**From:** Tim Screen <Tim.Screen@Cherwell-DC.gov.uk>  
**Sent:** 02 November 2021 10:55  
**To:** Nathanael Stock <Nathanael.Stock@Cherwell-DC.gov.uk>  
**Subject:** 21/02893/REM - OS Parcel 4300 North Of Shortlands And South Of High Rock, Hook Norton Road, Sibford Ferris

### Notes on Landscape and Visual Matter

Drawing file: A318-PP03A.pdf

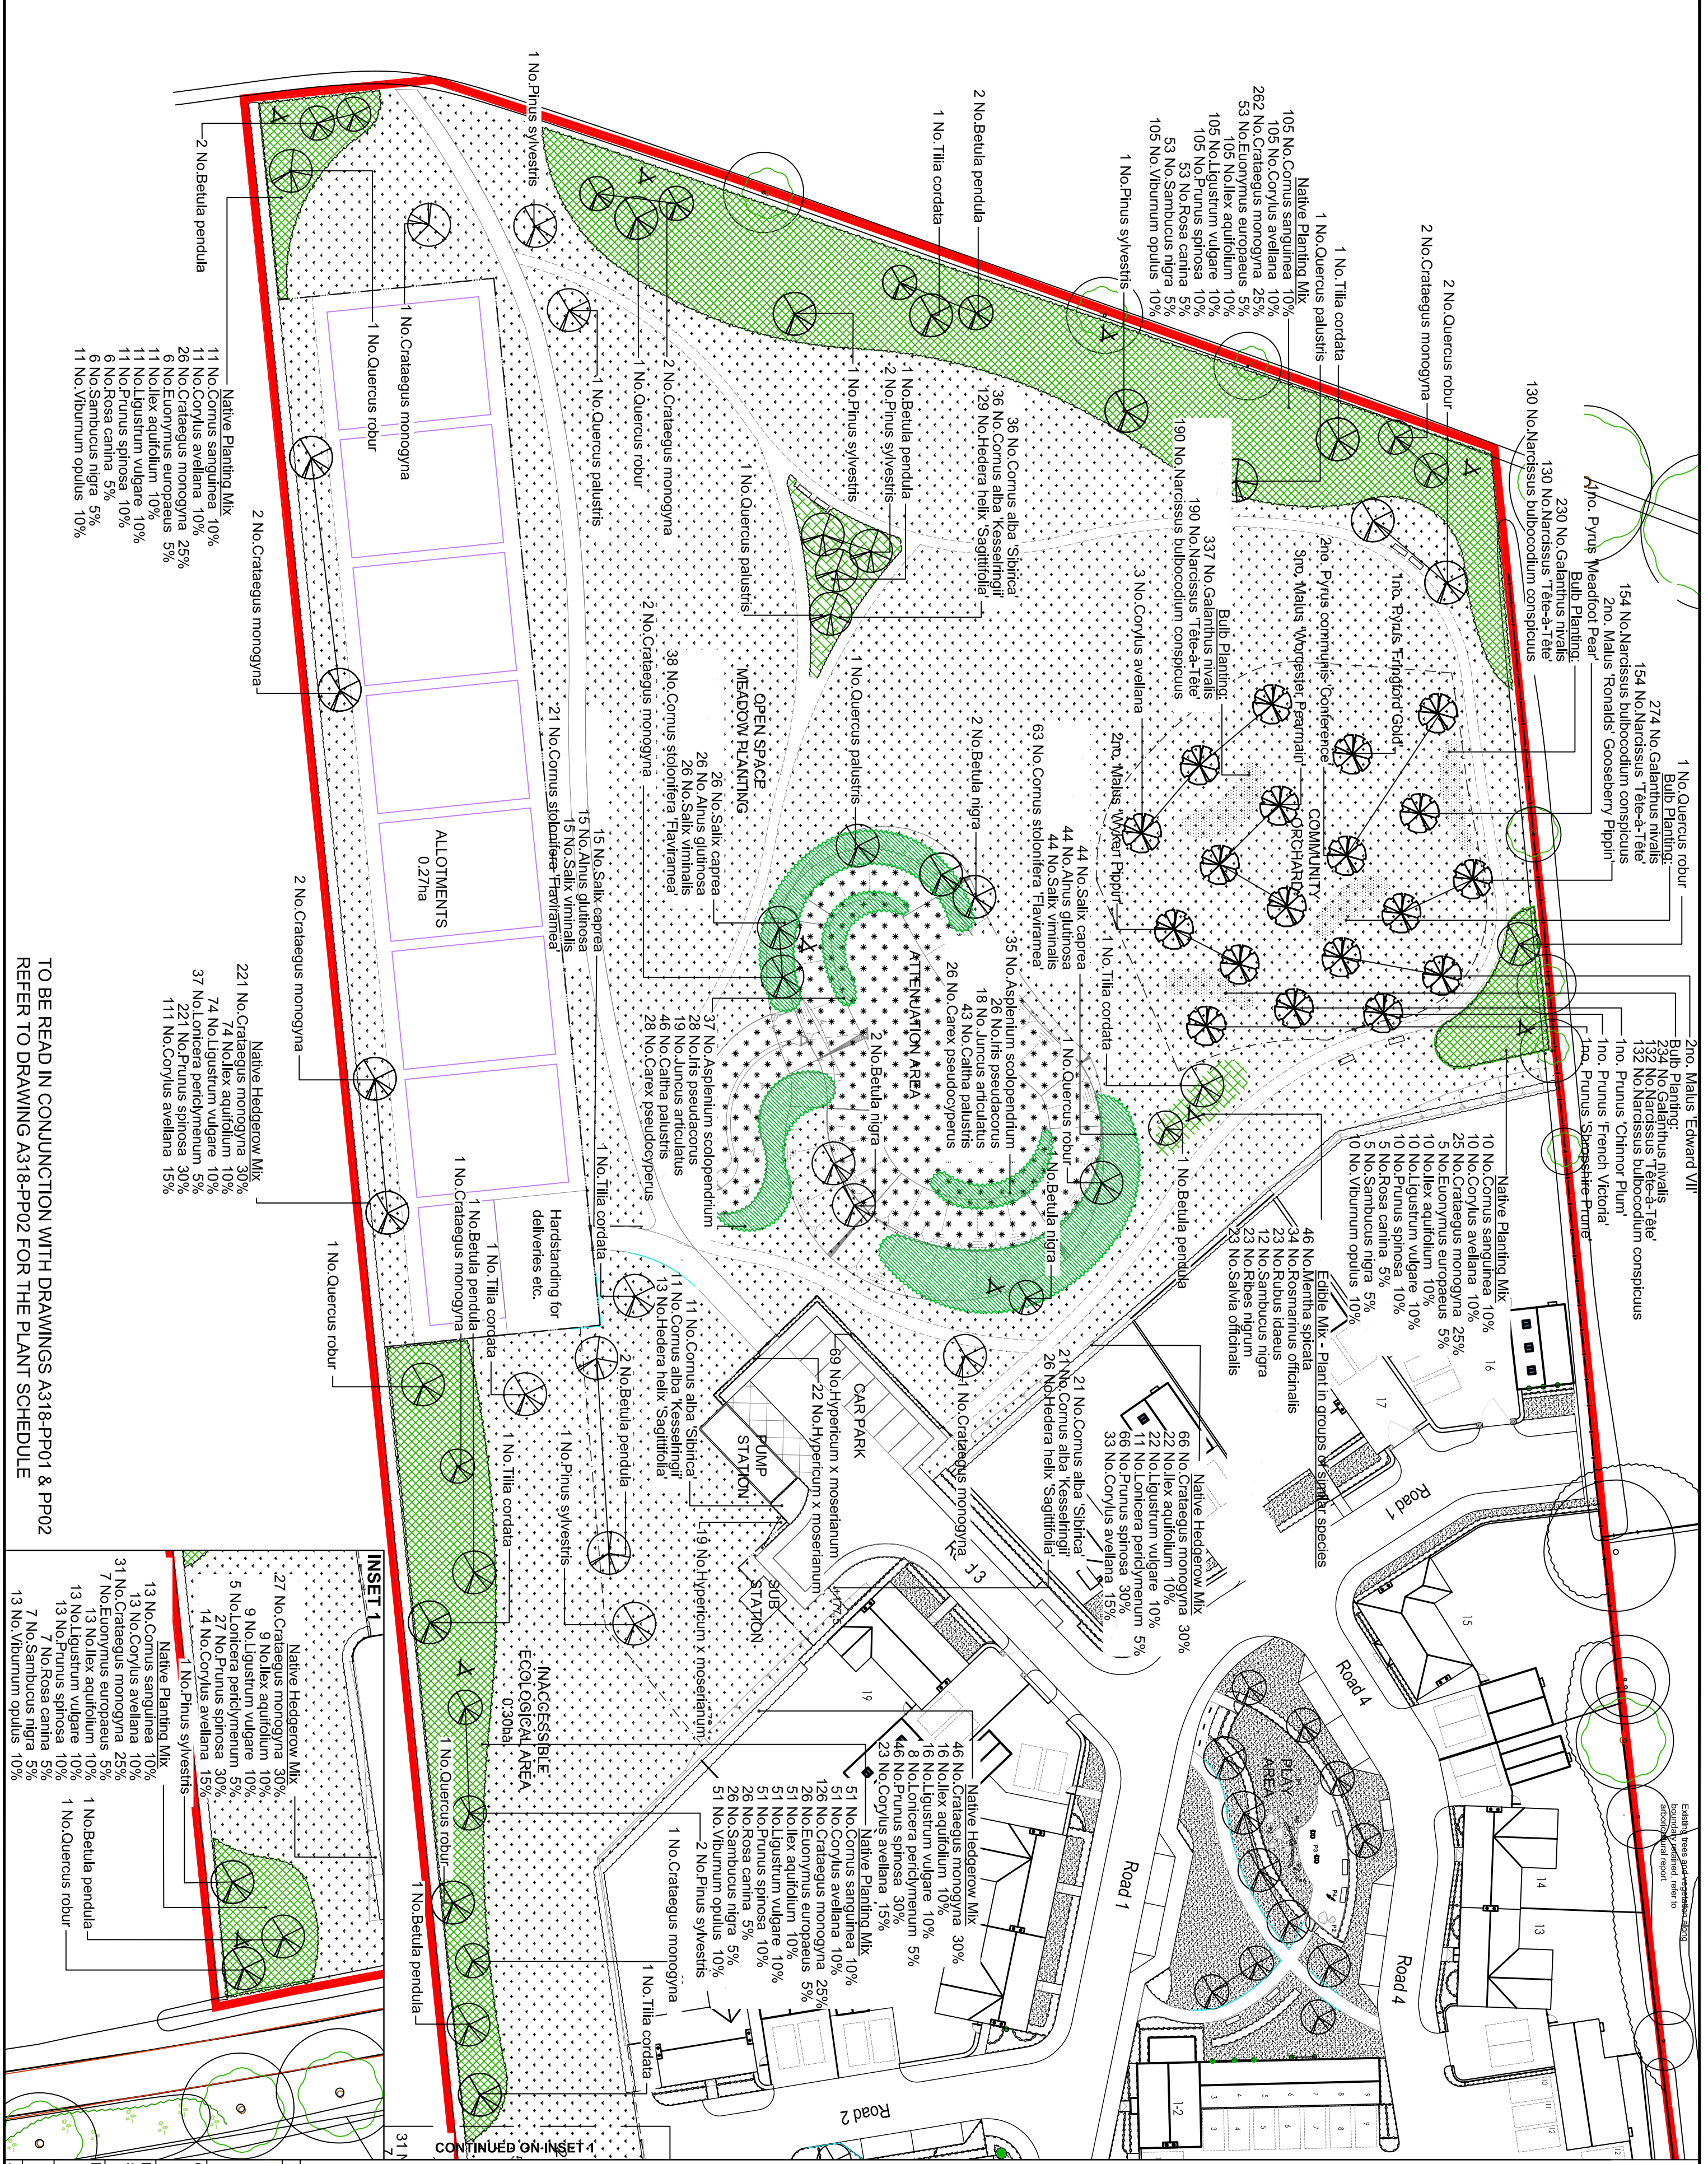
1. All trees should be at least 2 m from the edge of paving and root deflectors installed and indicated as such on the planting proposal plans.
2. There is no secured maintenance access for the restricted ecological area. This area is of ecological importance and therefore should be included in an overall LEMP report for the green space.

3. The allotment holders should have a 3 m wide access route to enable the delivery of bulk supply of compost and manure close to be deposited on hardstanding near the allotments. The proposed access route that meets the western boundary should be realigned to allow for the delivery of manure etc.

4. The access off the car park must be controlled with a lockable field gate to prevent unauthorised trespass onto the open space. This 3 m maintenance, allotment route should have detailed construction proposals that indicate a macadam surface with concrete kerb edging. The appropriate CBR/weight bearing is required to allow landscape maintenance vehicles (transit van and trailer, tractor with trailer) to use it.

5. The car park will be unsecure against unauthorised access to the open space, therefore requires robust estate railings around its perimeter with low level groundcover beneath it to ensure clear natural surveillance. A 1 m wide mown grass verge between the path that runs parallel to the car

park of the edge of the car park is necessary to ensure that cars do not park over the path with the wheels against the kerb which will restrict pedestrian access. The estate railing fence should be erected to the outer edge of the path with a steel pedestrian gate at the northern access and another steel pedestrian gate at the western access.

6. The trees proposed for the orchard are not proposed to be grafted to dwarf rootstock to keep the growth of the trees to a manageable size where pruning and fruit picking can be done from ground level.
7. The relevant British Standards should be clarified within the planting specification and aftercare proposals provided - refer to crib sheet enclosed. I await the Management Plan to accompany the landscape proposals.
